From: Louisa Walker [REDACTED]
Sent: 11 August 2026 10:28
To: Planning; [REDACTED]
Subject: Applicant Response to Third Party Comments – Planning Application 3/2026/0452

South West Elevation

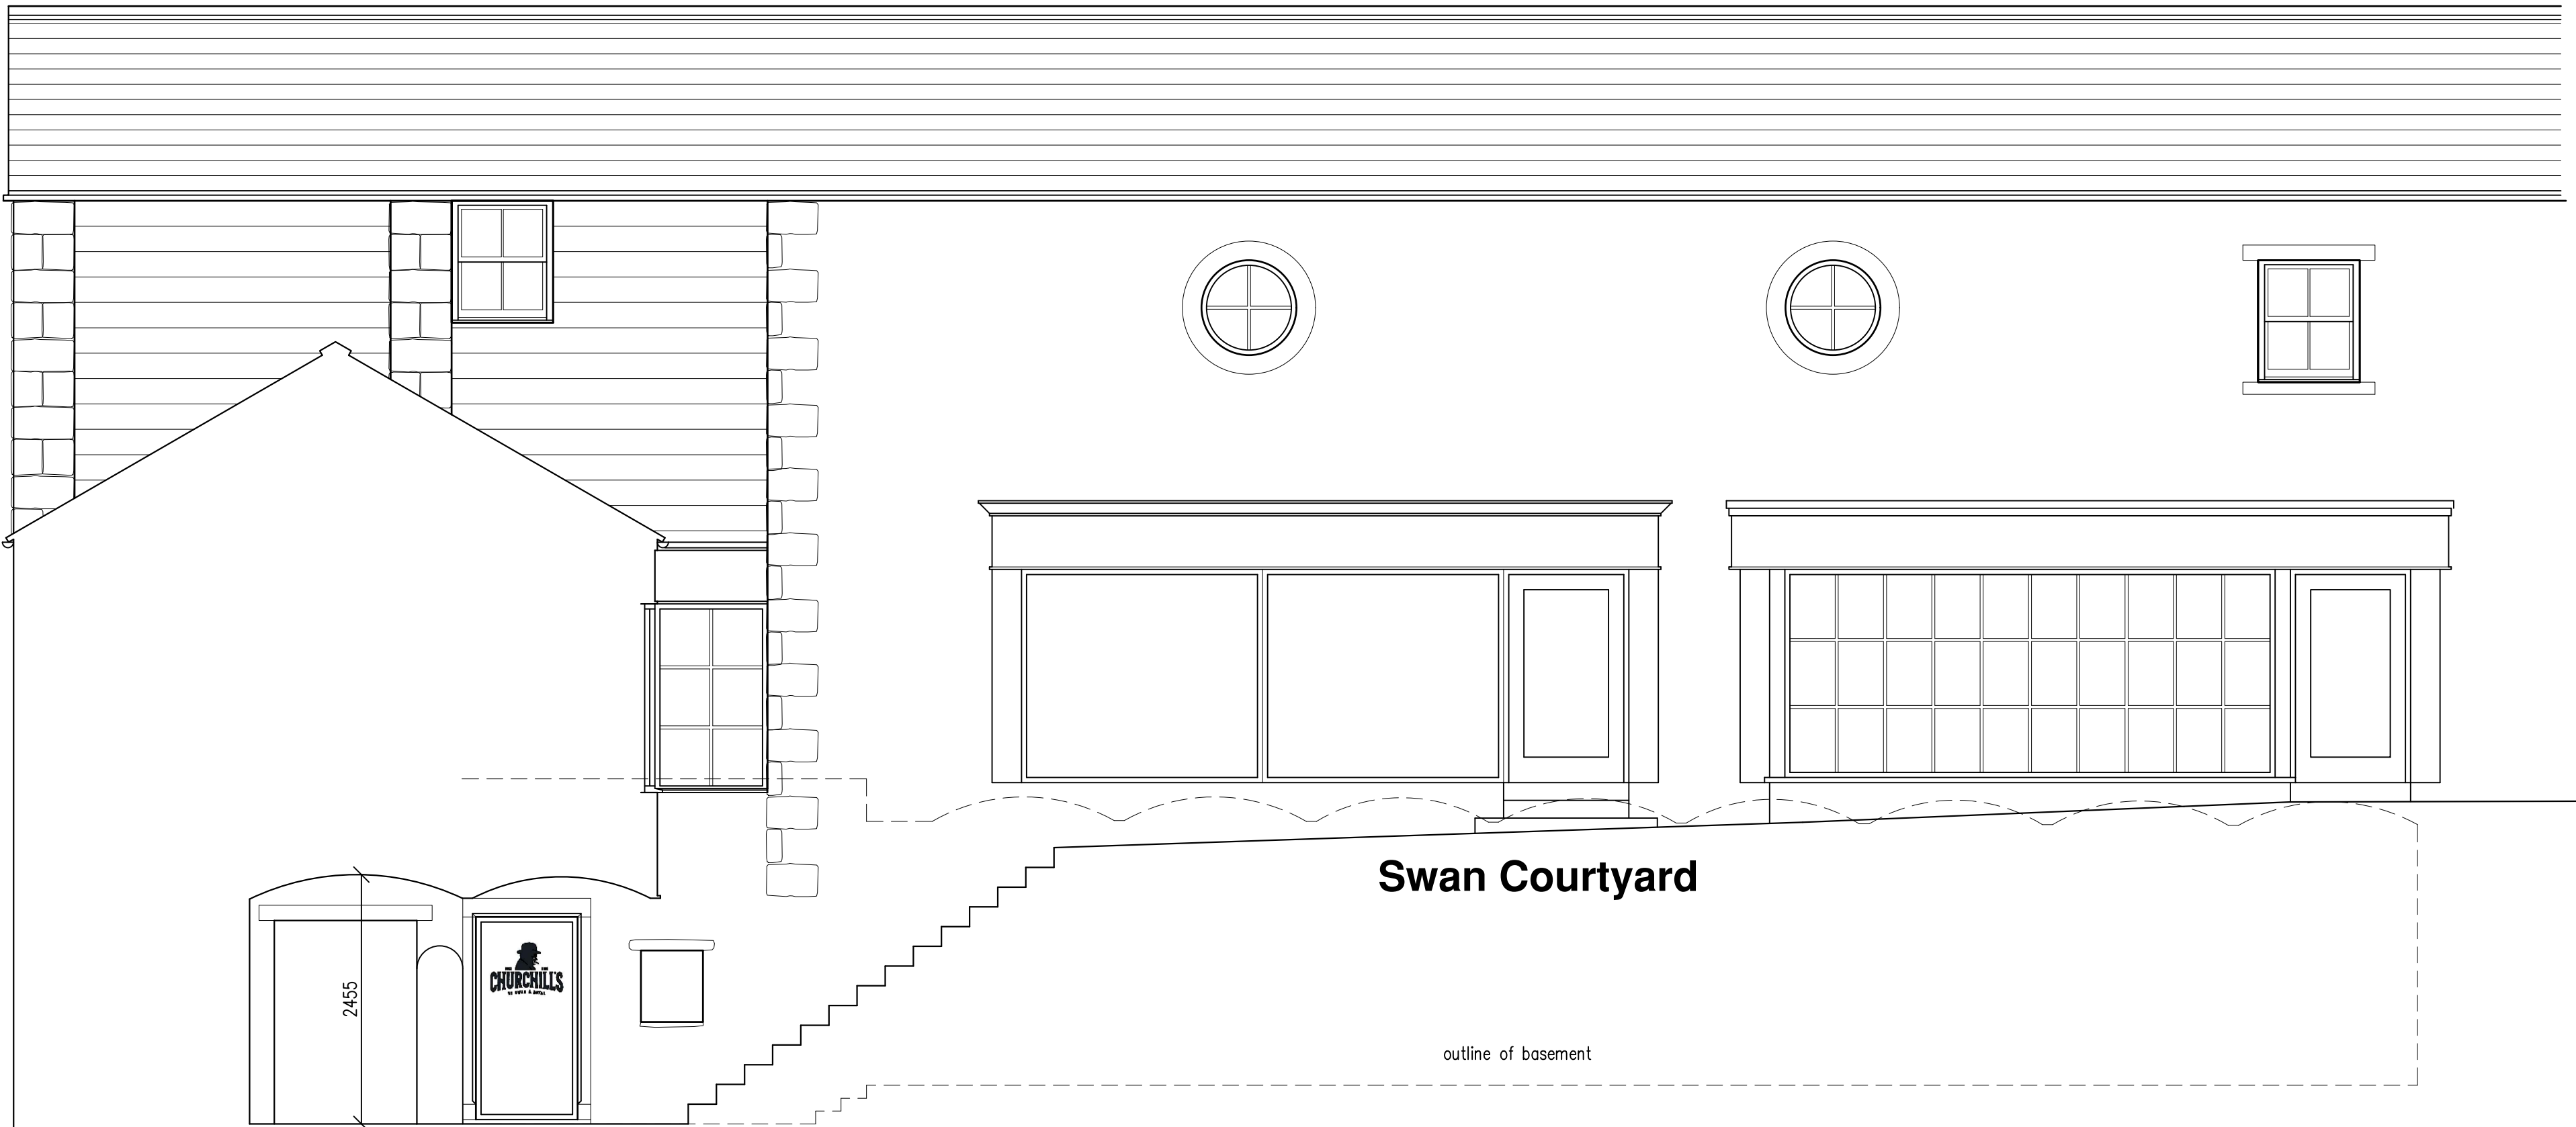
2. Doors within the Existing Archway

We can confirm that the proposed doors are intended to remain open at all times during normal operating hours and are not intended to restrict public access between Lowergate Car Park and Swan Courtyard. The doors will not have keyholes and are not designed to be locked in a manner that would impede pedestrian access through the archway.

It is not our intention to obstruct or restrict this established pedestrian route, and we trust that this clarification addresses the concerns raised.

job: Proposed Restaurant & Bar 3A Swan Courtyard Clitheroe BB7 2DQ client: Mr L Nuttall		
drawing: Proposed		
scale: 1:50, 1:20 @ A1	date: 04/26	drawn: smc
job no: 30/2026	drawing no: 02	F

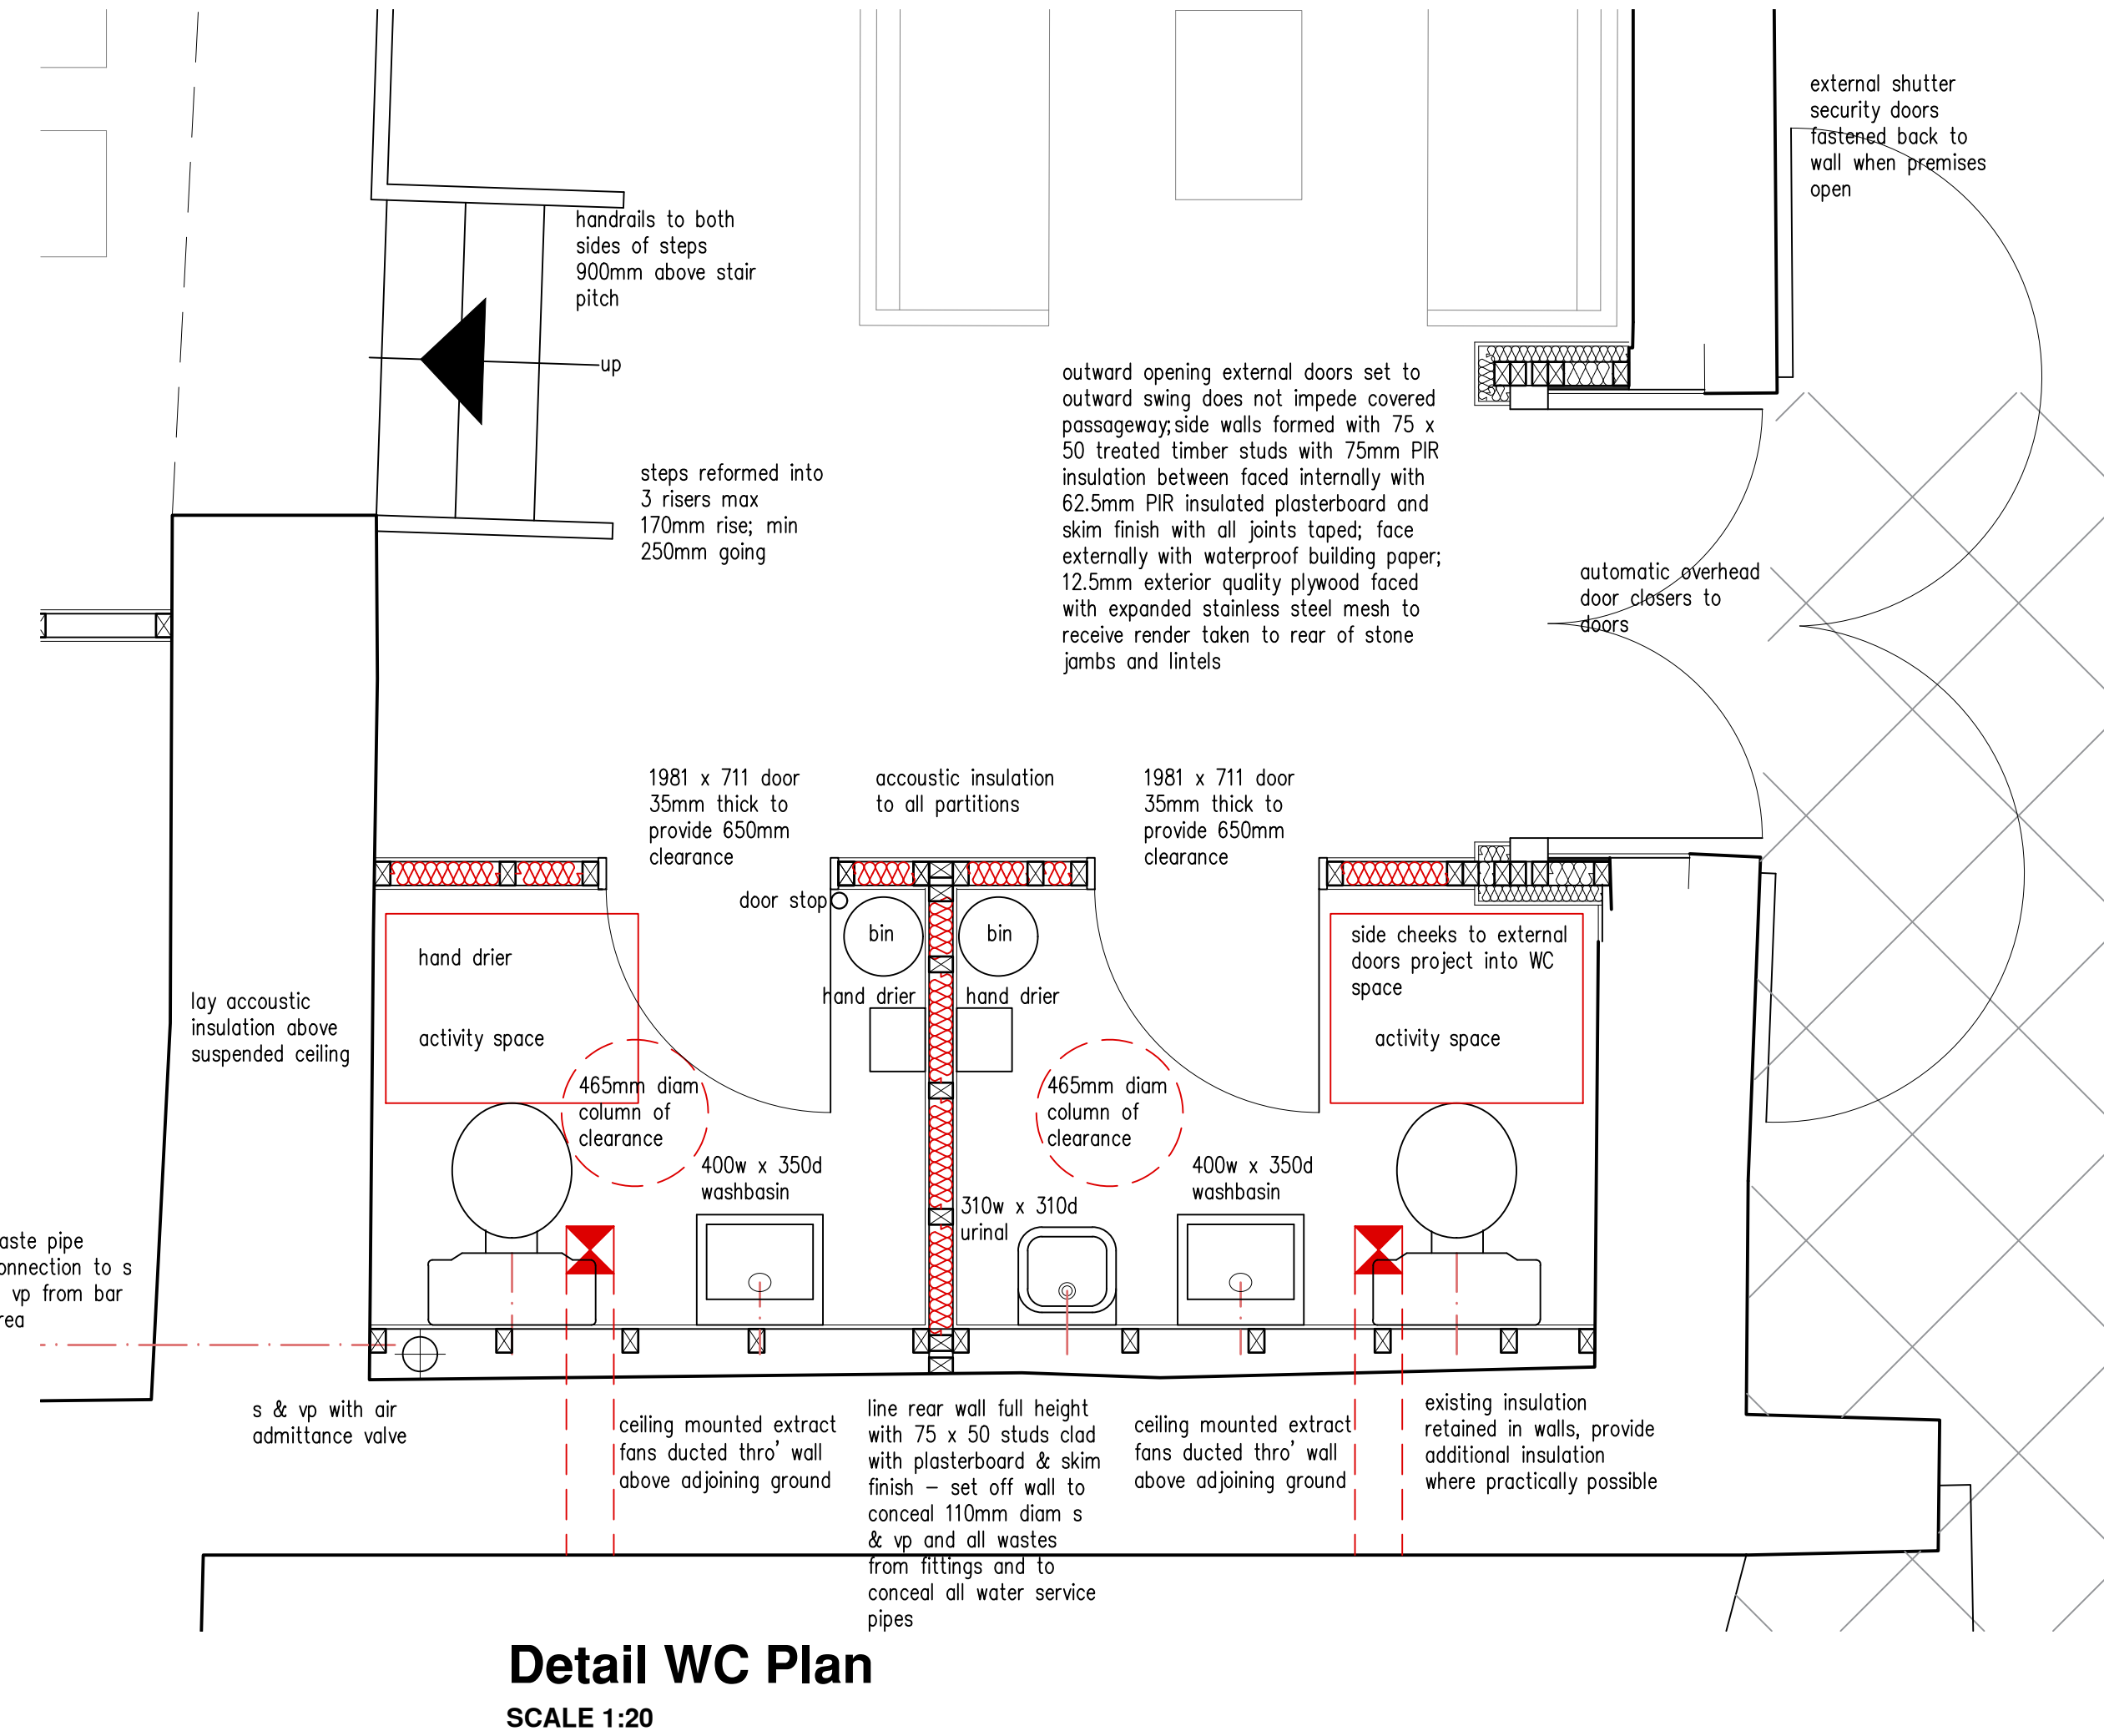
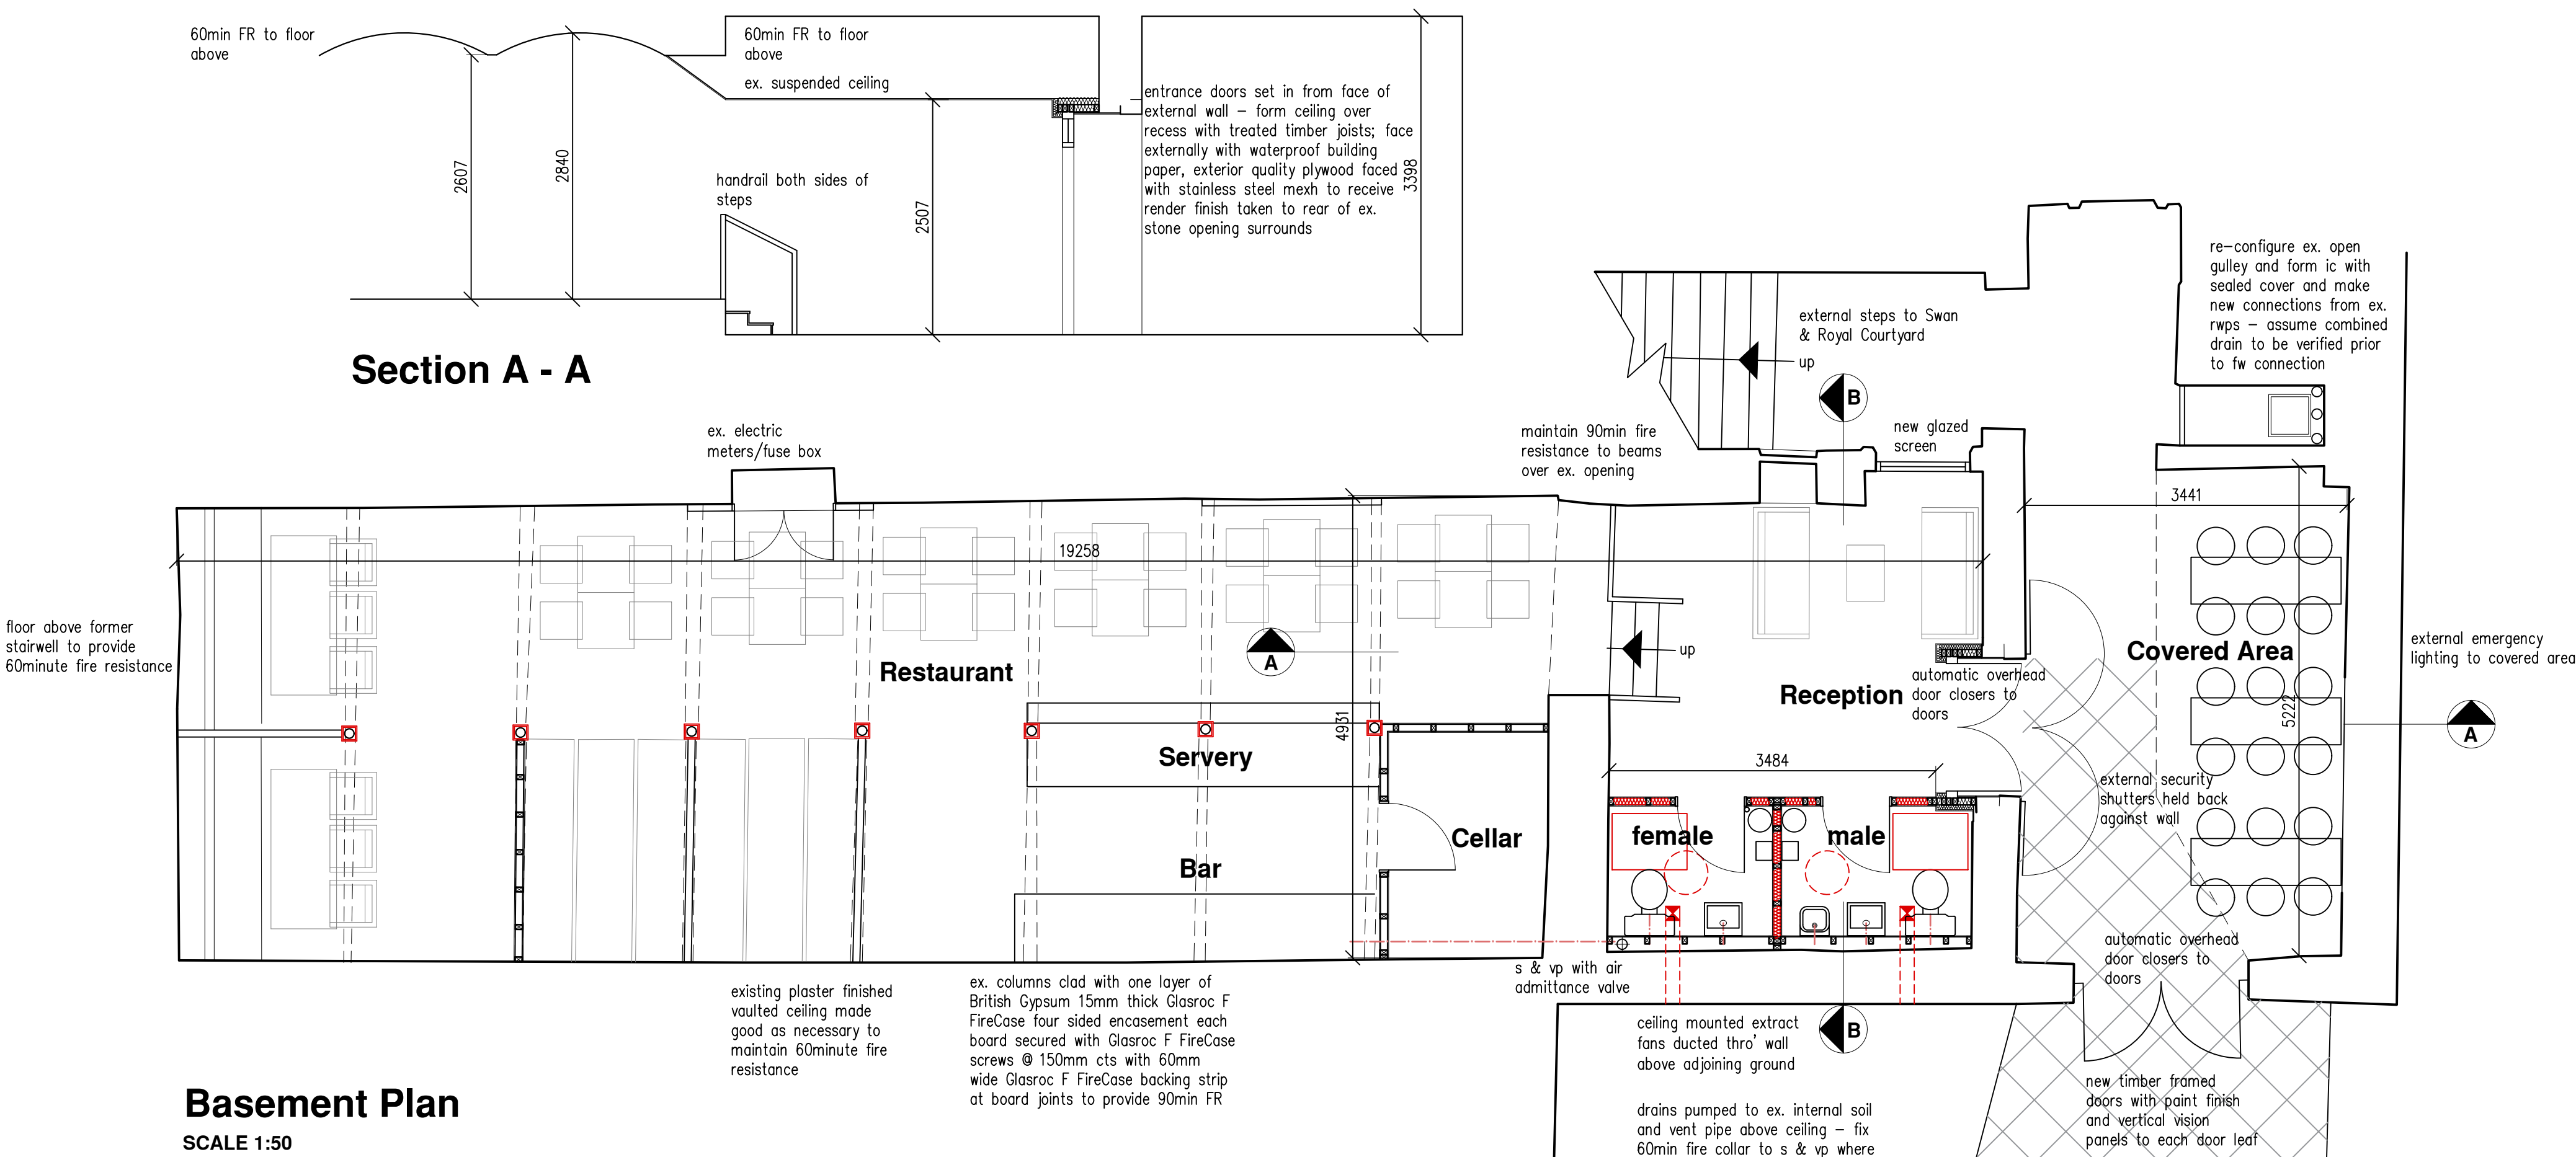
1. Mechanical Ventilation – Male and Female Toilets

We can confirm that each of the proposed male and female toilet facilities will be fitted with its own dedicated mechanical extraction fan. These will provide the required ventilation for each toilet independently.
